From: [Marc Kirkpatrick](#)
To: [Zach Torrance-Smith](#); kristinaowens11@gmail.com
Cc: [Jamey Ayling](#); [Bradley Gasawski](#); [Chace Pedersen](#); [Owens Meats](#)
Subject: RE: SP-23-00012 KD Properties - Transmittal of Comments
Date: Thursday, January 18, 2024 4:08:06 PM
Attachments: [image001.png](#)
[21006 P-SP SHEET 1 \(1-11-2024\).pdf](#)

Subject: SP-23-00012 KD Properties - Transmittal of Comments

**KD PROPERTIES SHORT PLAT**

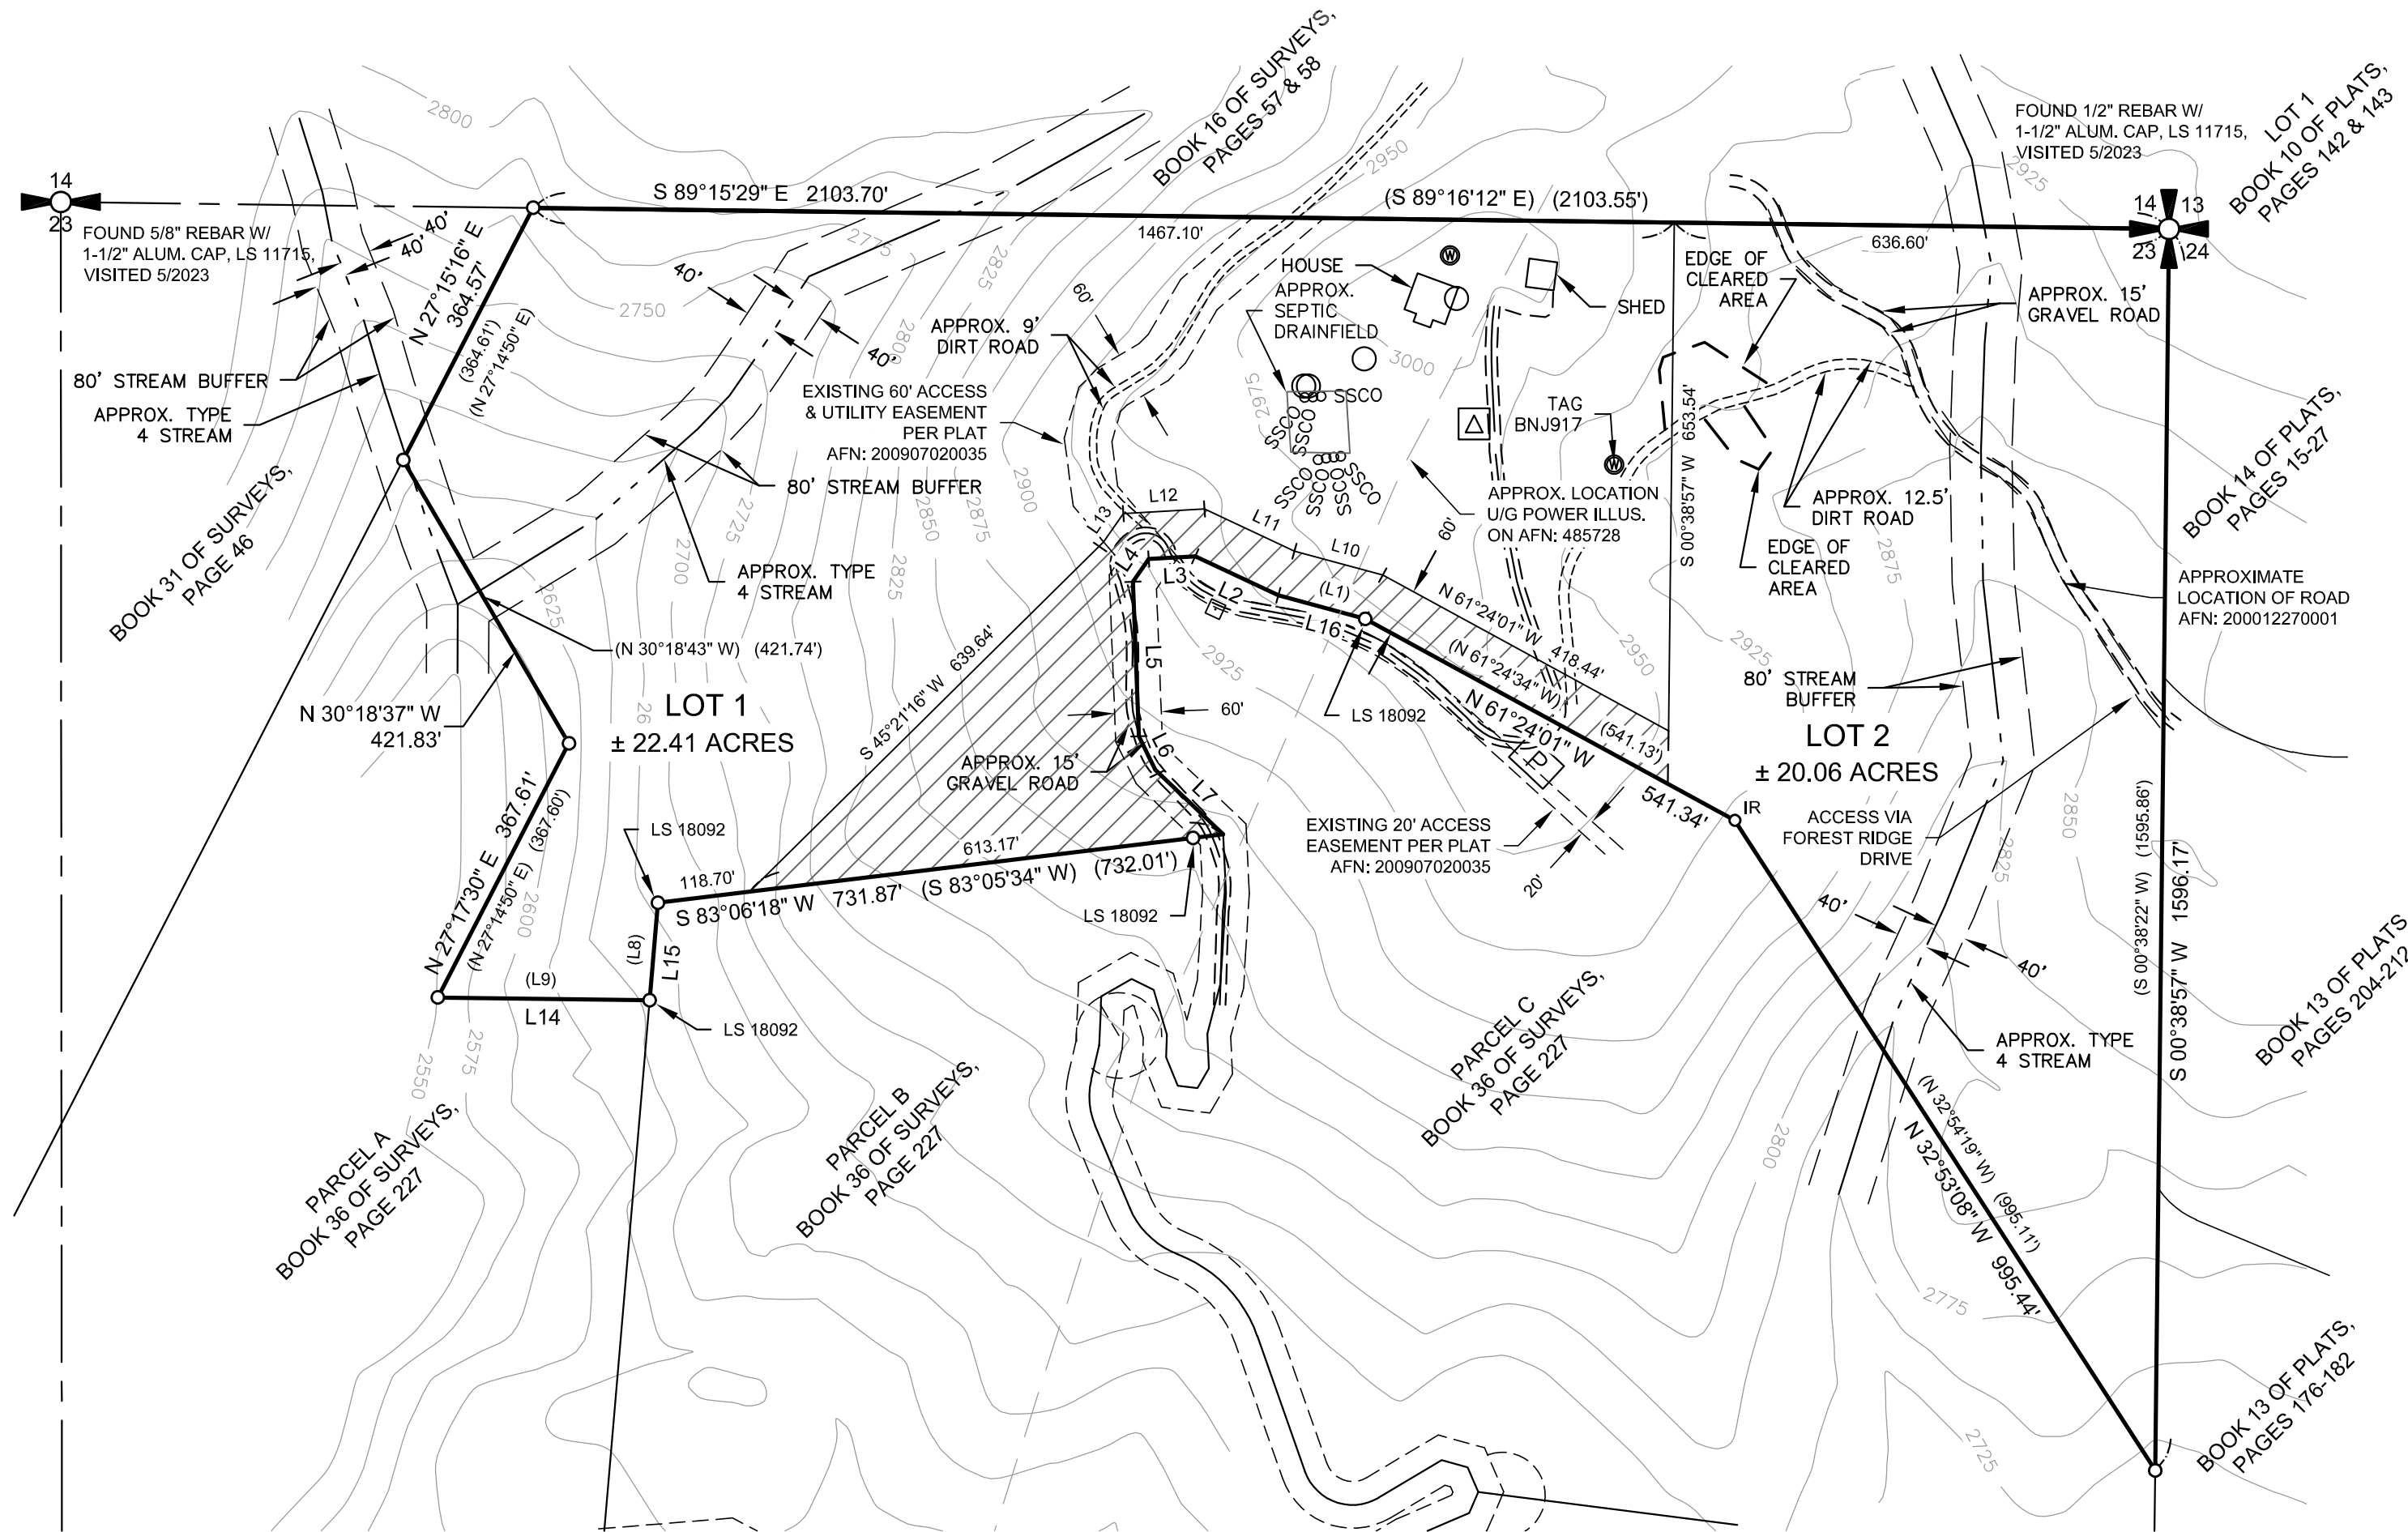
- *Public Works Comments* – Applicant and Encompass will comply with requirements.
- *Fish & Wildlife Comments* – Please see attached map for stream locations and buffers for a Type 4 Stream. With the site being 40+ acres, development already

completed on Lot 1, and future development on Lot 2 will need to go through a building permit process, we ask not to require preparing a critical area report at this time. This report, if needed, could be done in the future if and when a building permit is applied for.
